RESPONSE TO REVIEWER COMMENTS

To: Grace Manahan  
City Planner, Mercer Island

RE: 2306-124 SUB1 PLANS  
Hong + Kao Residence

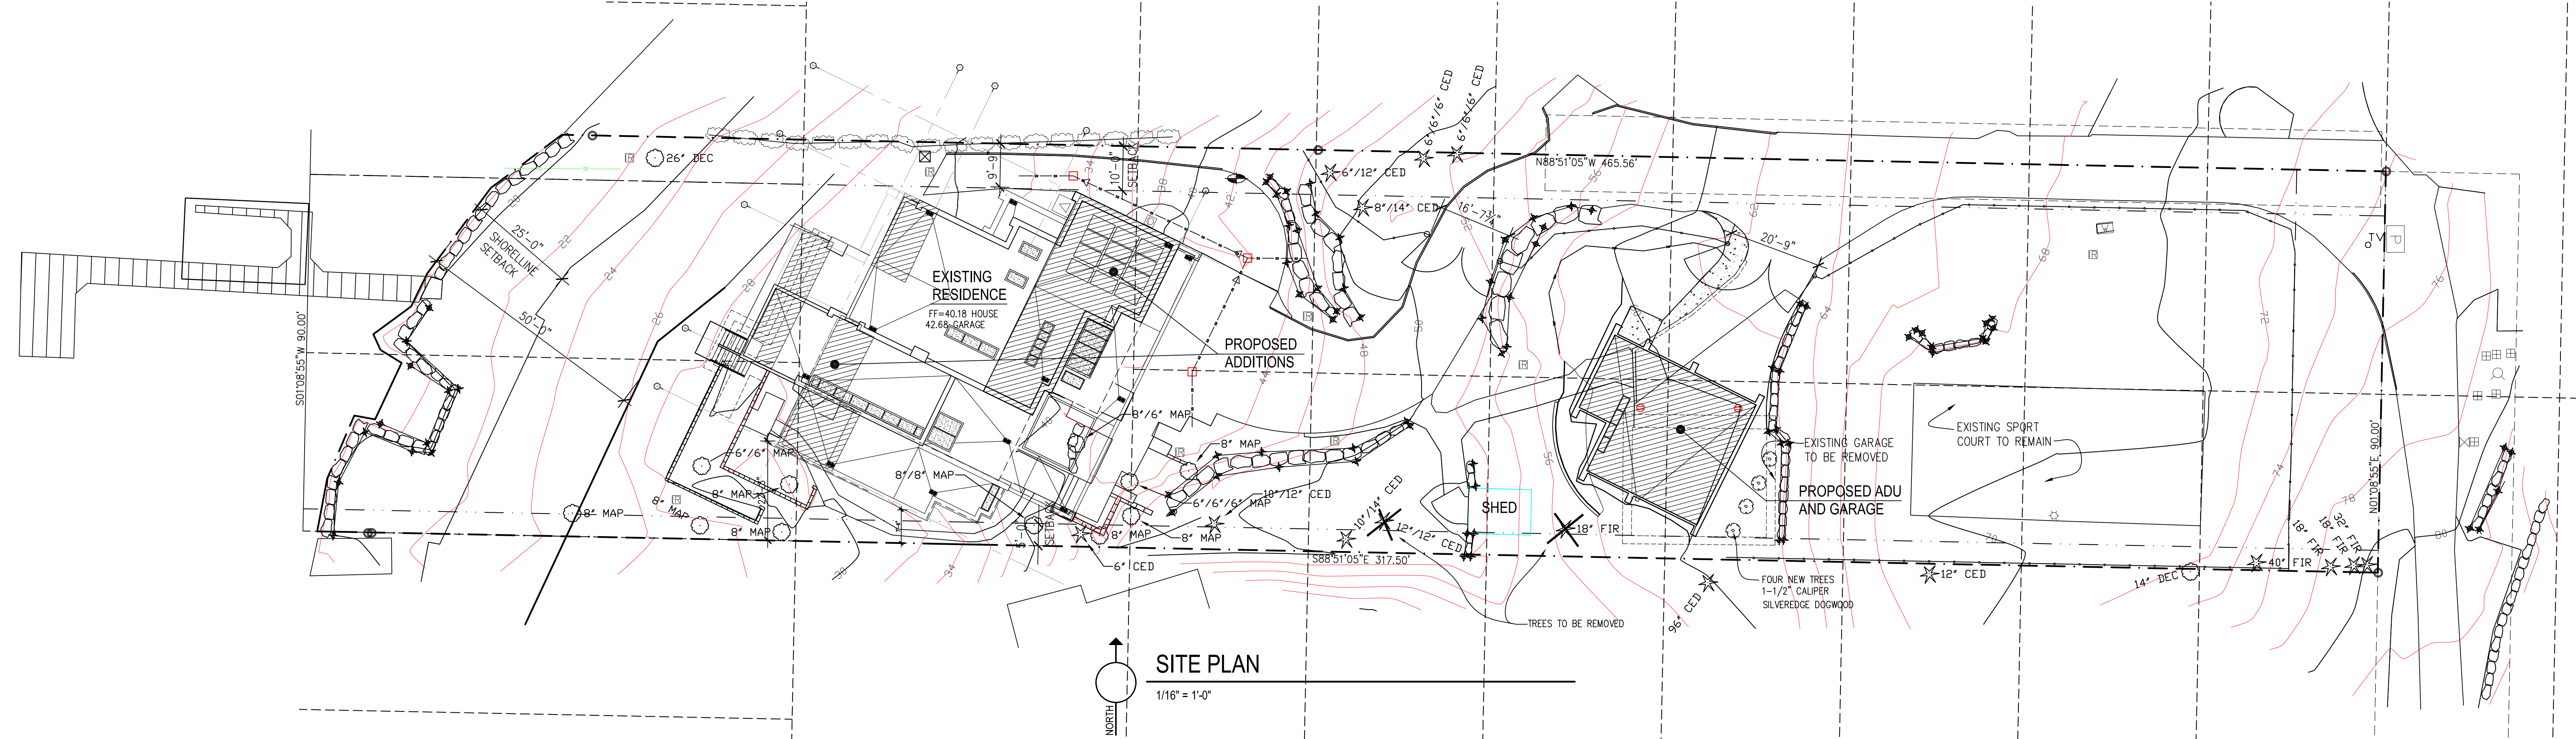
1. a. The existing shared access easement is 17'-0" wide. The north property line of the 5425 property is 8'-1 ¼" into the easement. The proposed fence within the building setback, 10' south, or 1'-10 ¾" south of the easement. The fence will be about 2'-3" south of the edge of the existing pavement.

- b. The fencing itself has not been designed. An open fence like chain link would allow visibility, but is not very aesthetically pleasing. The owners intend to landscape the property and the fence design will be part of that work.

- c. The City of Mercer Island requires that gates be equipped with a means of opening by emergency personnel.
- d. The fence as located complies with codes and requirements of the City of Mercer Island. Final placement is to be determined but will be no closer to the property line than as shown.
